RE: 75 Douglass St.

Your application to demolish garage and replace on same footprint, has been reviewed and a permit is herewith issued subject to the following requirements:

REASON FOR PERMIT: Demolish garage, rebuild same footprint.

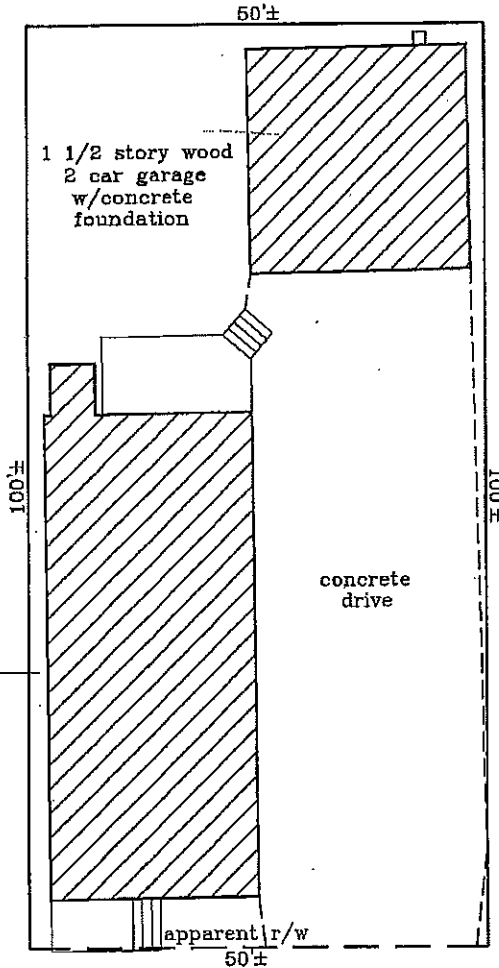
1. This permit is being issued with the understanding that the proposed structure does not encroach any closer to side lot lines. The expansion of the garage in width will take place on the back portion of your yard, not the outboard.
2. The length expansion will be in the front of the proposed garage not the rear.
3. As you stated, the existing garage was not 18' X 27' as permit stated but was 19' X 23' and it was built in 1949.
4. Please read and implement items 1, 2, and 13 of the attached building permit report.
